WEST SUSSEX COUNTY COUNCIL CONSULTATION

TO:	Arun District Council FAO: Kathryn Welch
FROM:	WSCC - Highways Authority
DATE:	3 February 2022
LOCATION:	88 Ancton Way, Elmer, PO22 6JP
SUBJECT:	M/6/22/PL Demolition of existing bungalow and erection of 1 No 2-storey, 4-bedroom detached house with 3 No off road car parking spaces. This site is in CIL Zone 4 and is CIL Liable as new dwelling.
DATE OF SITE VISIT:	N/A
RECOMMENDATION:	Advice
S106 CONTRIBUTION TOTAL:	N/A

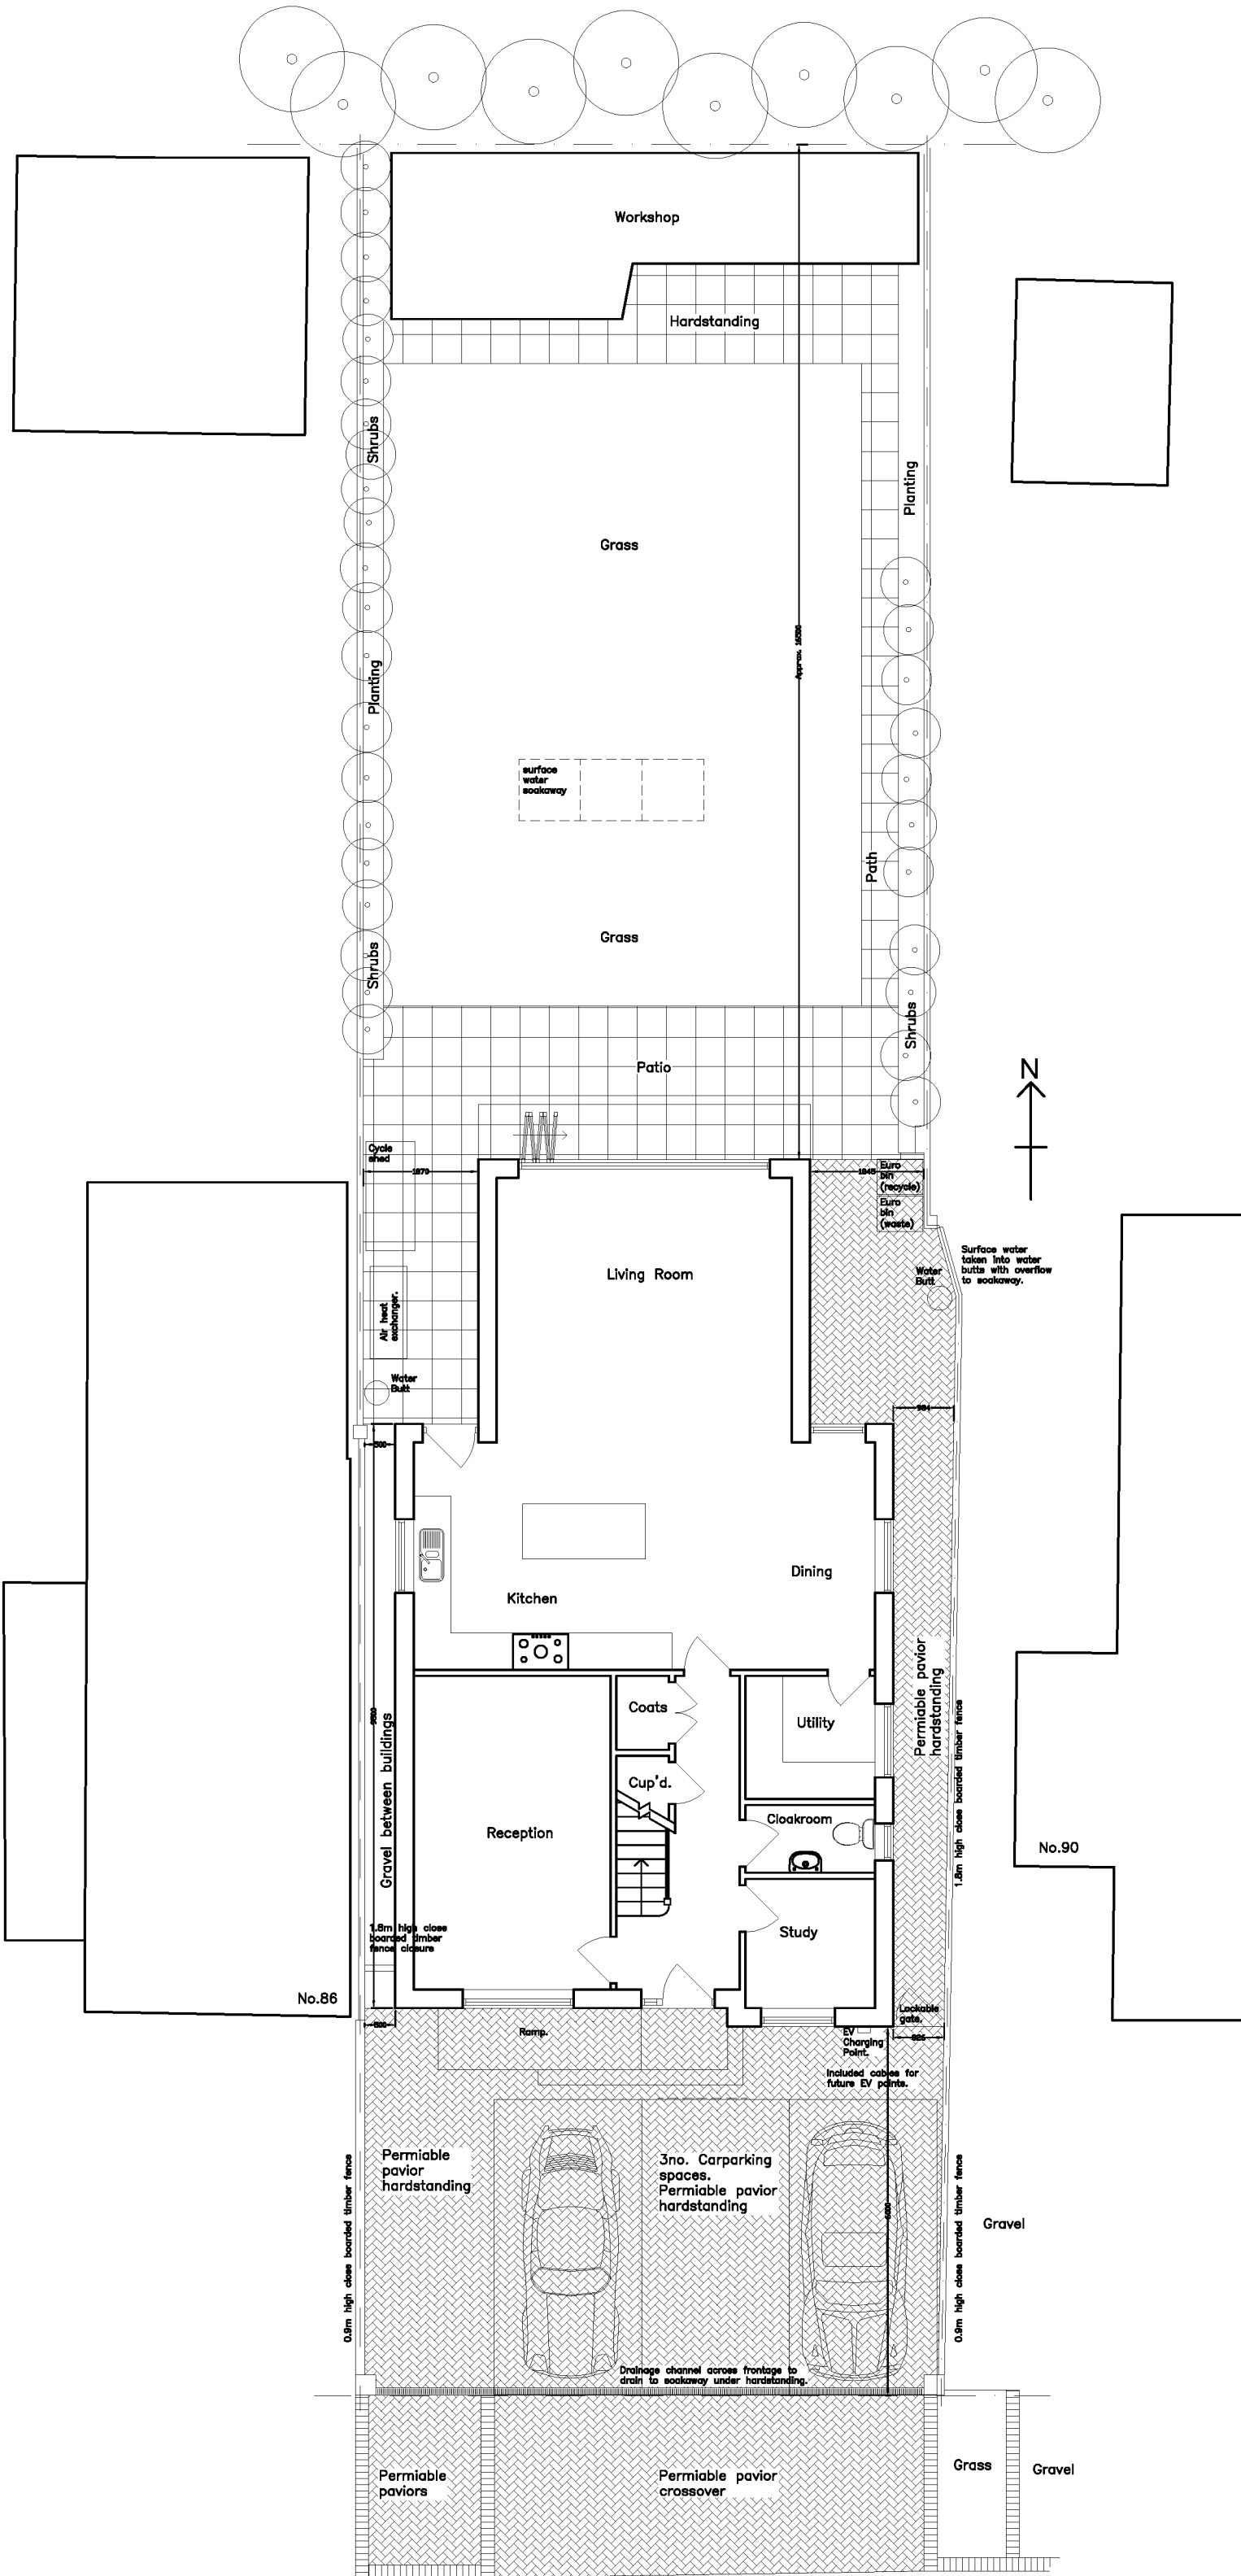
The applicant proposes to widen the existing vehicular access across the site frontage. As this road is privately maintained, the applicant should contact the proprietor of the road to obtain formal approval for the proposed access works.

The applicant proposes three car parking spaces fronting the proposed dwelling. Under Arun Parking Standards, the LHA would expect a parking provision of three parking spaces for a dwelling of this size in this location. Therefore, the LHA is satisfied with the proposed parking provision.

From inspection of the plans, the proposed parking bays are suitably sized. On-site turning does not appear achievable, so cars may have to exit the site in a reverse gear. However, this is the existing arrangement and is not anticipated to result in a highway safety concern.
